New single Family home on Peaks Island - Frederick Avenue (Lyndon Ave.) - Permit #2016-00873

I have completed my initial zoning review and there are some things that I need before I can complete my zoning review.

1ST FLOOR PLAN
A-1.2
FOR PERMIT
NOT FOR
CONSTRUCTION

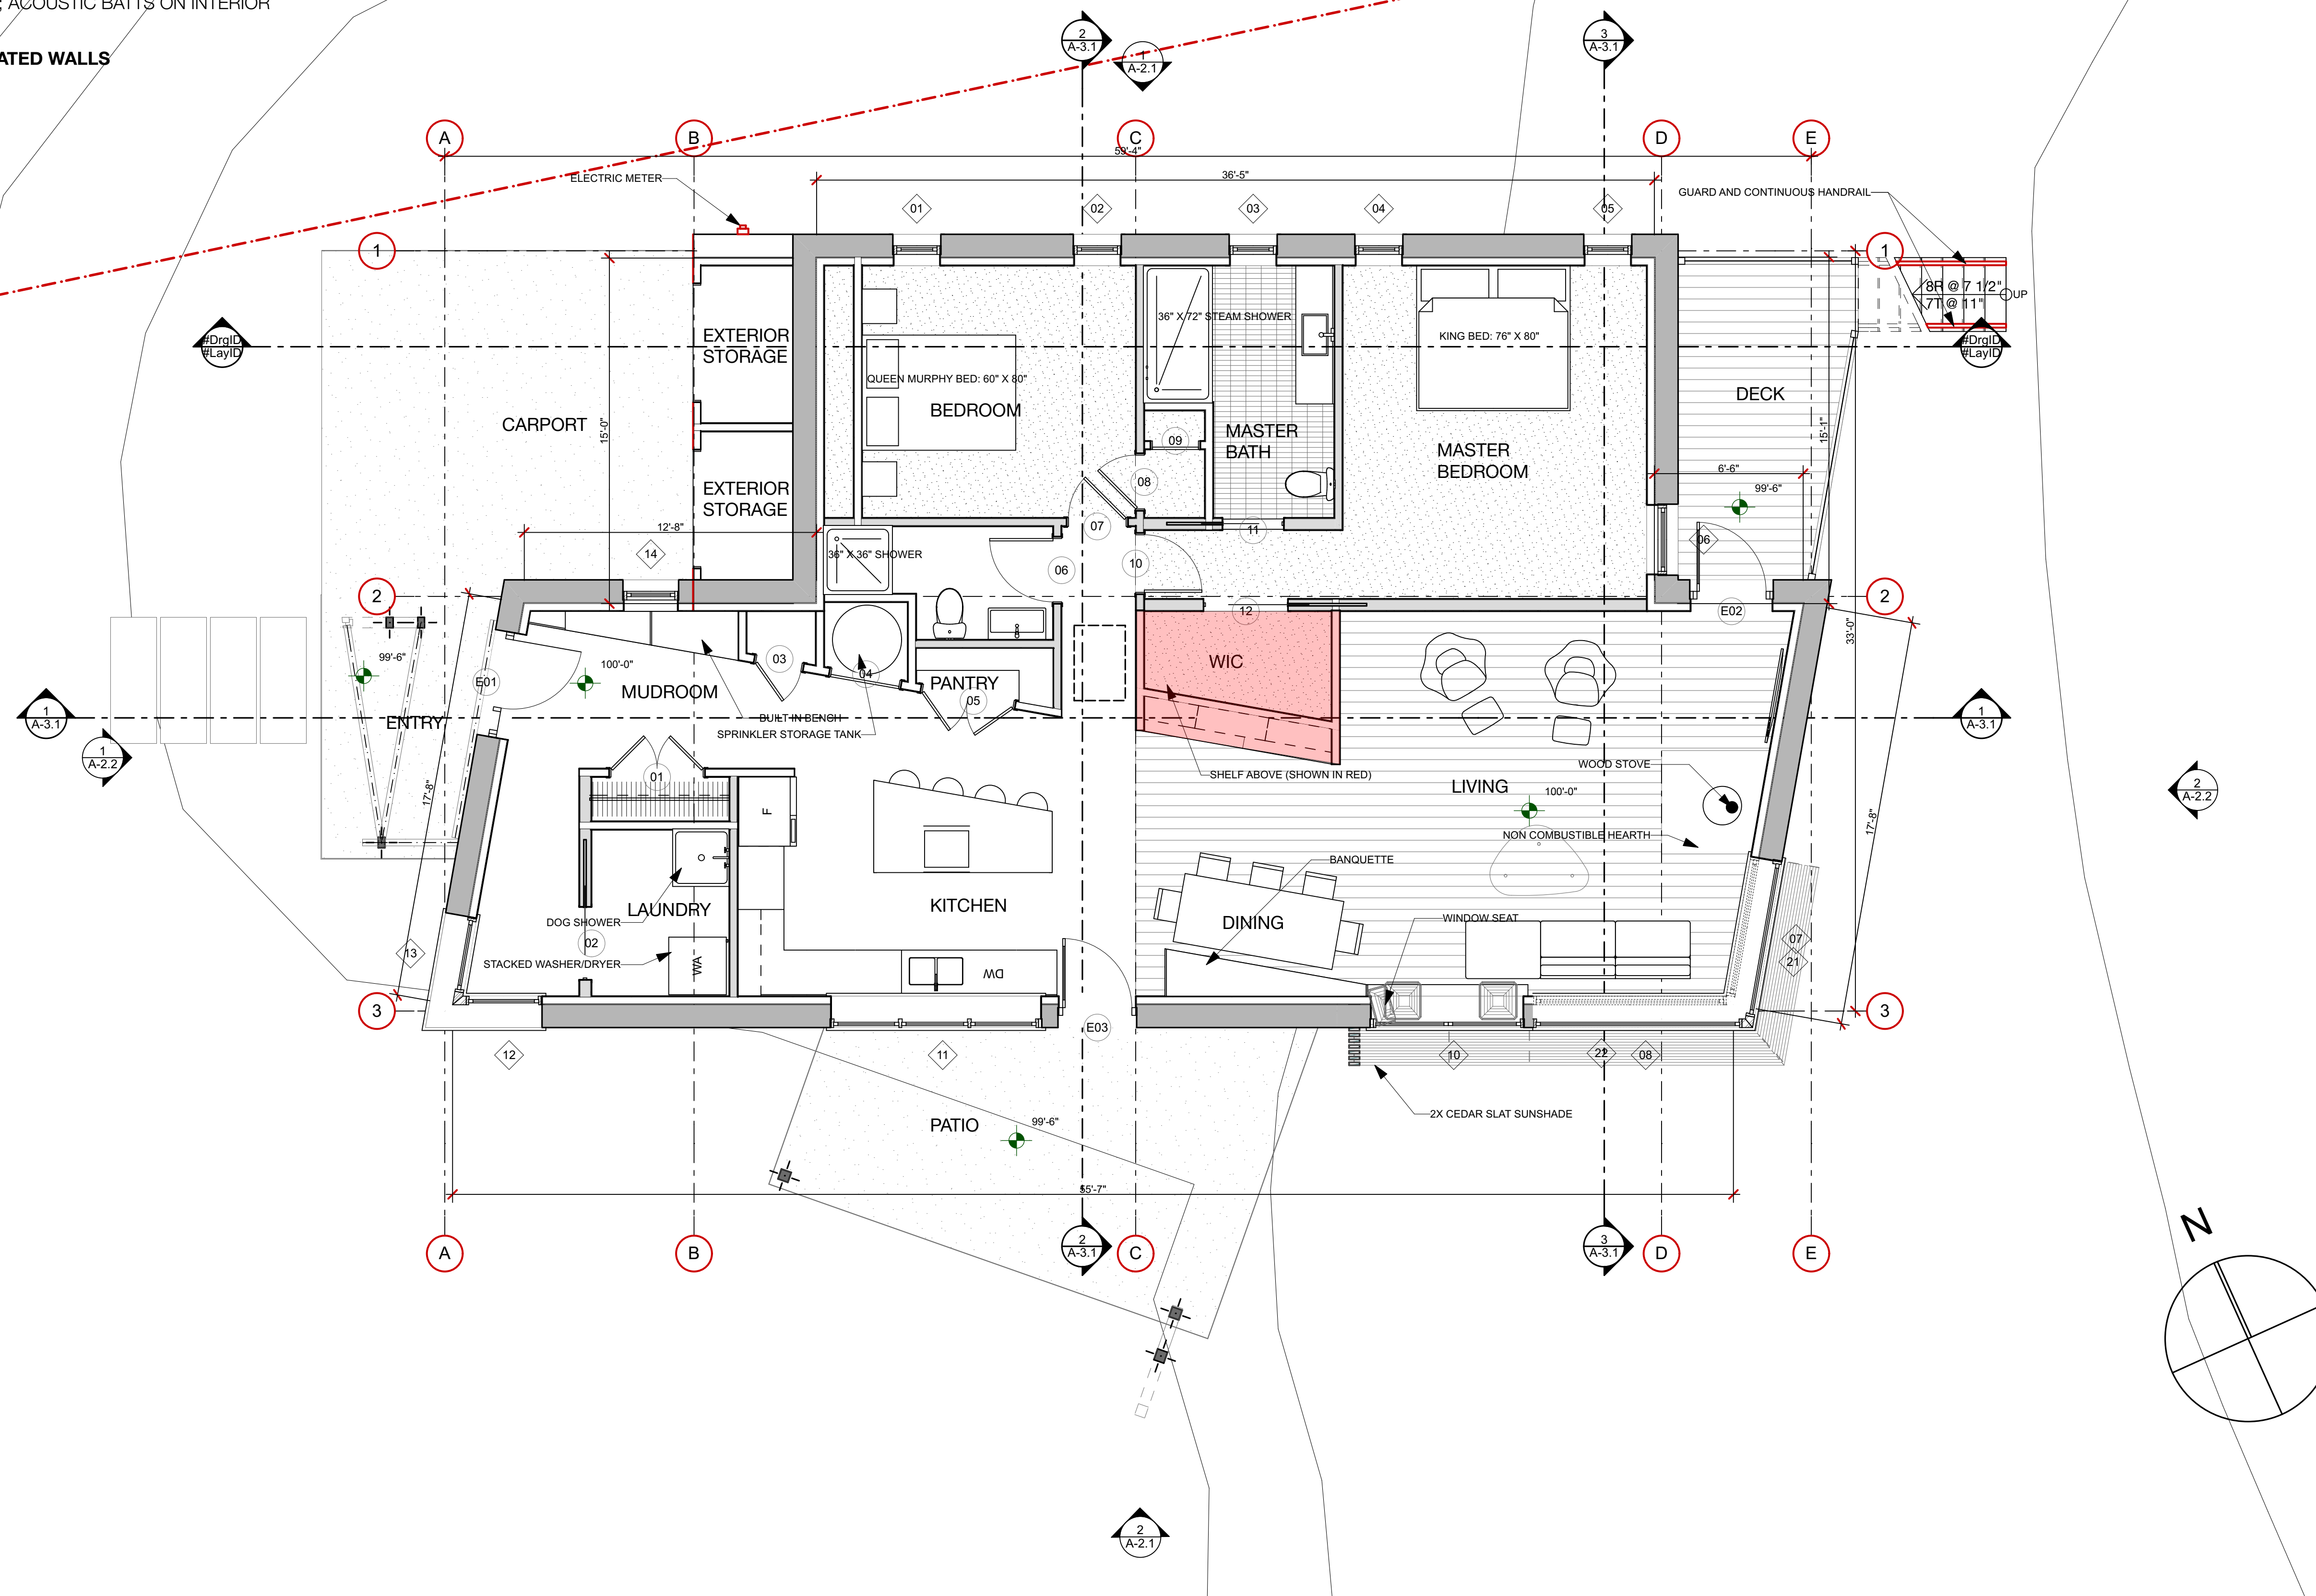
3. Speaking of the required parking spaces, plan A-1.2 shows a carport. It appears to scale at 14.35' x 16'. A parking space must be 9' x 18'. Please show two parking spaces on the site plan that meet this criteria.

**1 SITE PLAN**  
SCALE: 1/16" = 1'-0"

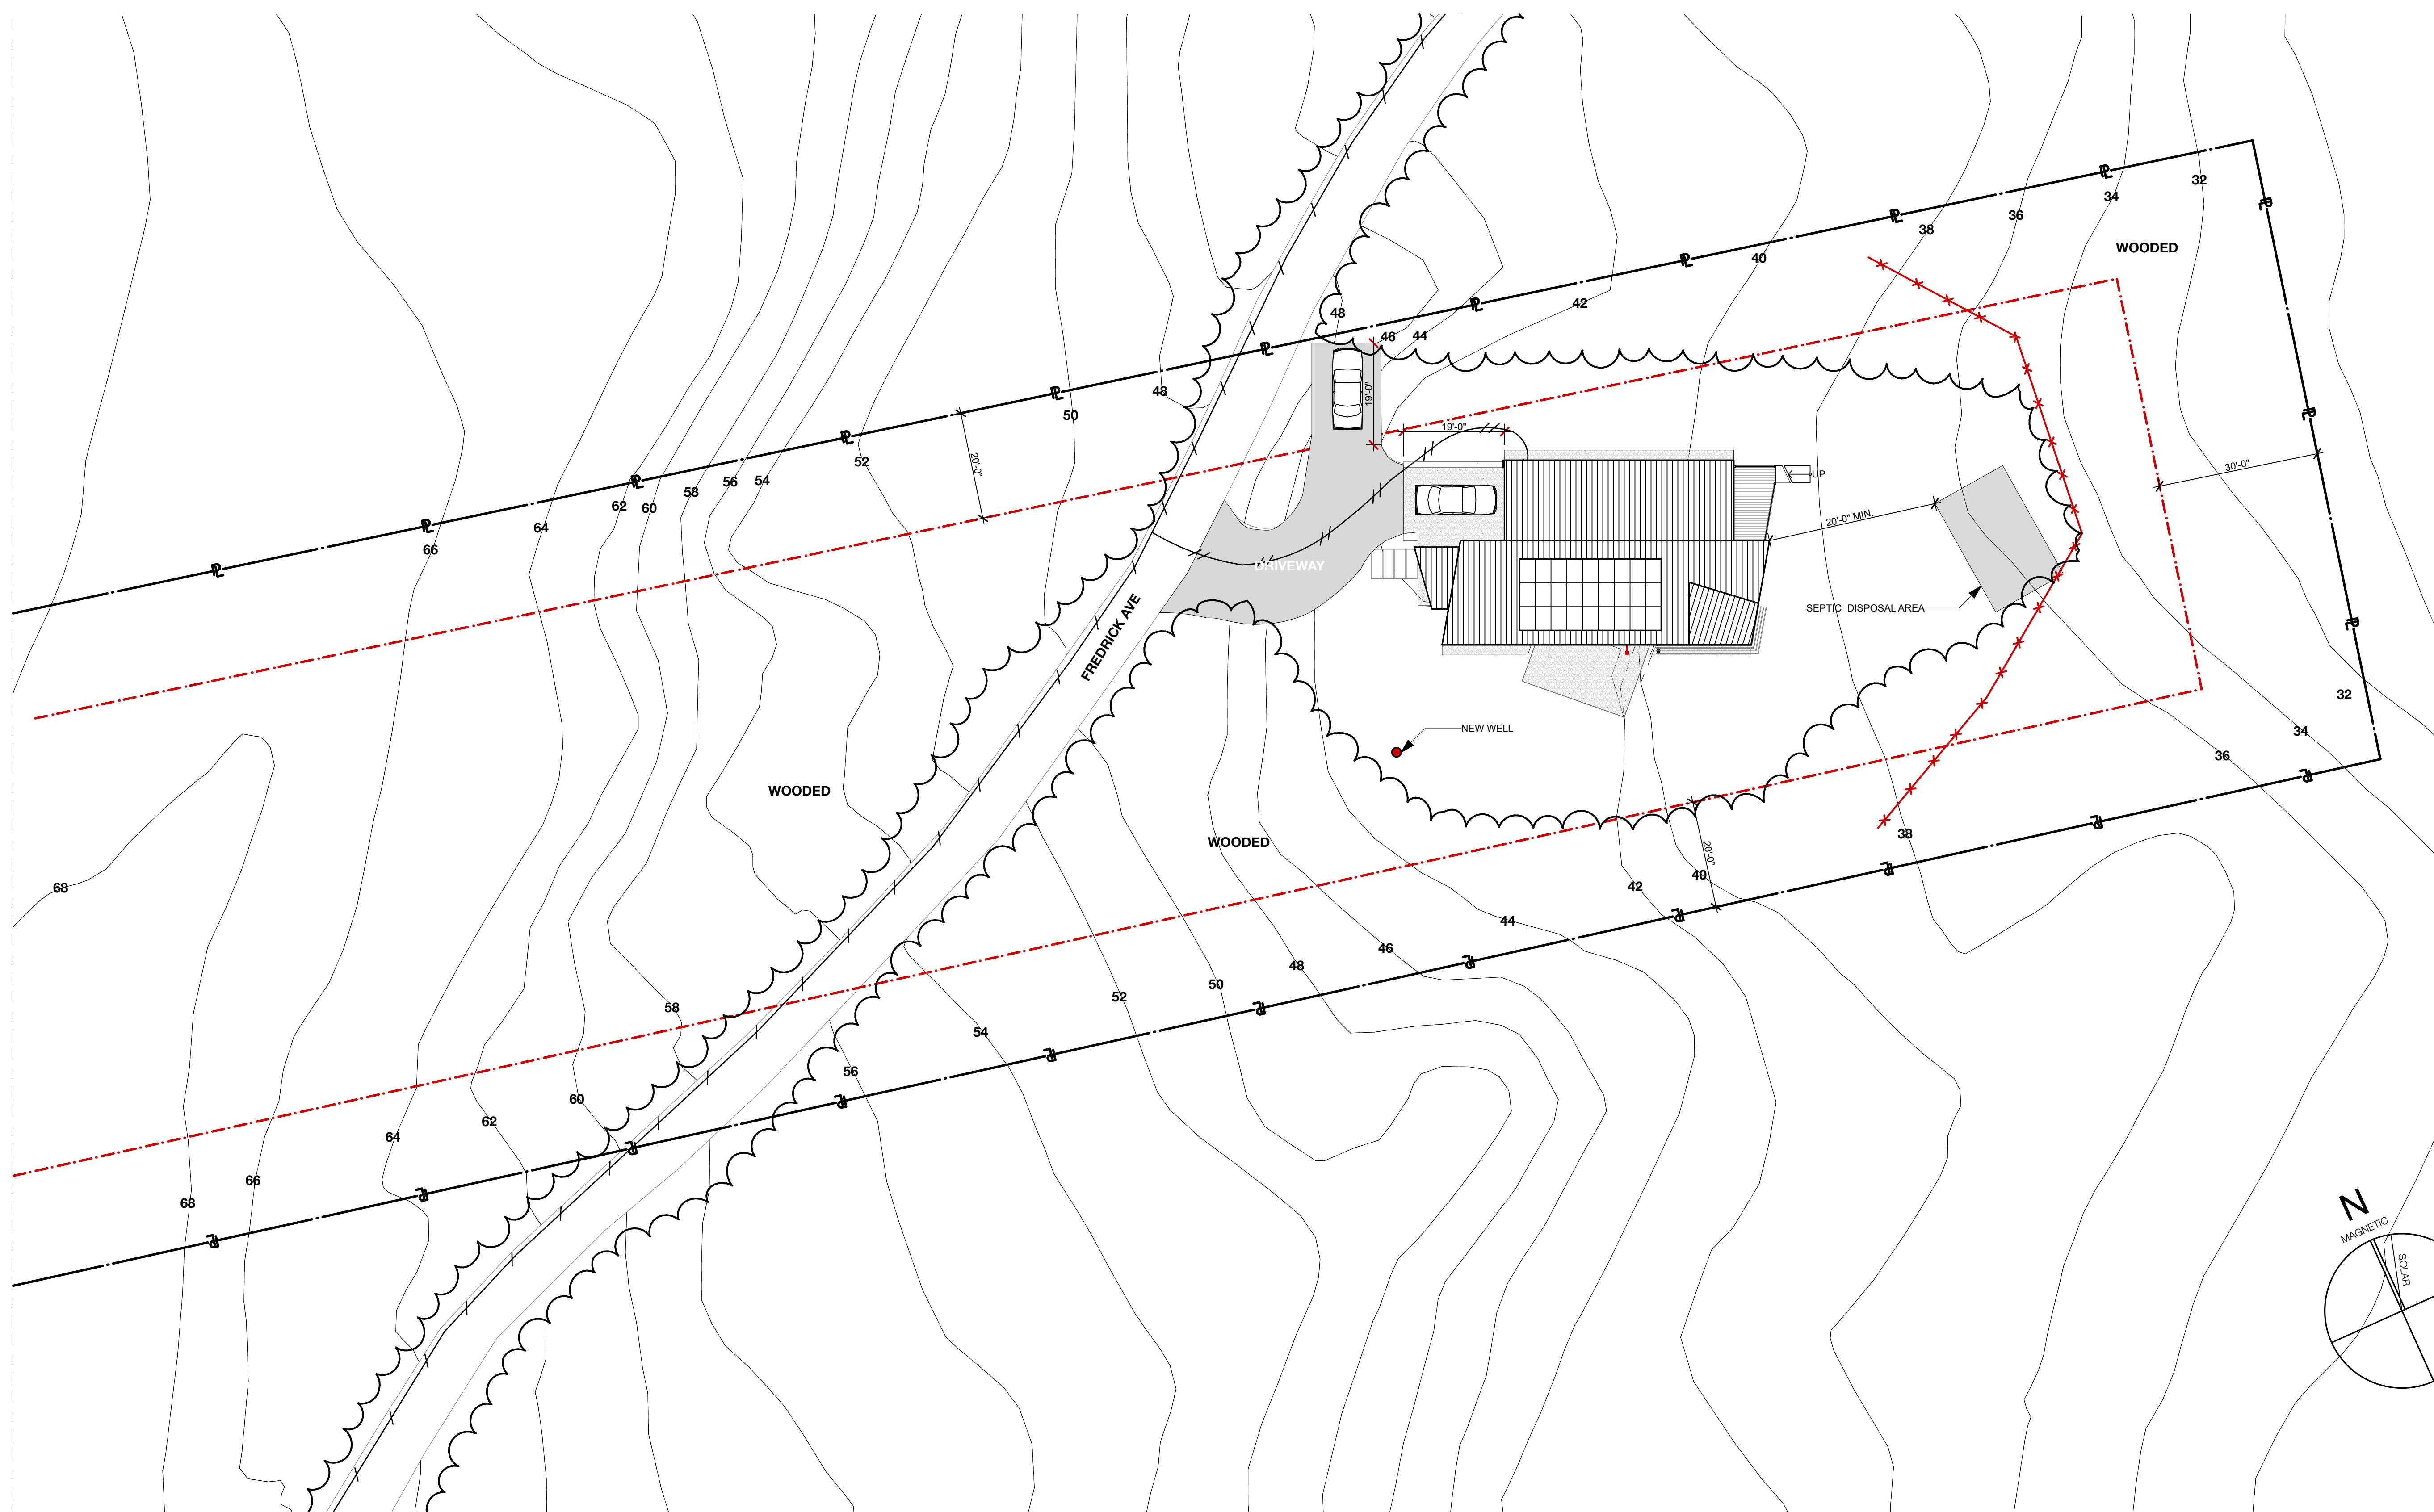
I need to determine that this section is being met. I have concluded that this lot meets the definition of a lot of record under section 14-433. As a lot of record, "access can be provided by a permanent easement or right of way. This easement or right of way must be a minimum of 16' wide and have a minimum travel width of 8'. The survey that was submitted with the application done by John Swan from Owen Haskell, Inc. shows Frederick Ave as a "path" that crosses the middle of the lot. This "path" scales at about 8' in width. On the site plan it appears to scale at over 9'. (The actual width is hard to determine because of the line with the single hash marks that runs through the lot on the path and branches off to the new house with two hash marks. There is no key on the site plan so it is unclear what this line is.) The original Plan Book, BK 13, Pg 81 (attached), for this lot (2B) shows Frederick Ave as a 40' wide right of way that ends at the southern side of the lot and then is labeled as a trail that runs through the property. I need confirmation that where Frederick Ave enters the southern side of the lot that it has a travel width of at least 8' so that the required access is being met.

In addition to this, you are required to have two parking spaces for a new single family home. Is the "path" that is shown going to be the driveway to access the new house?

4. What is the 14.4' x 23' gray rectangle on the site plan that is shown 20' off the back of the house? Is it a structure or a septic system?
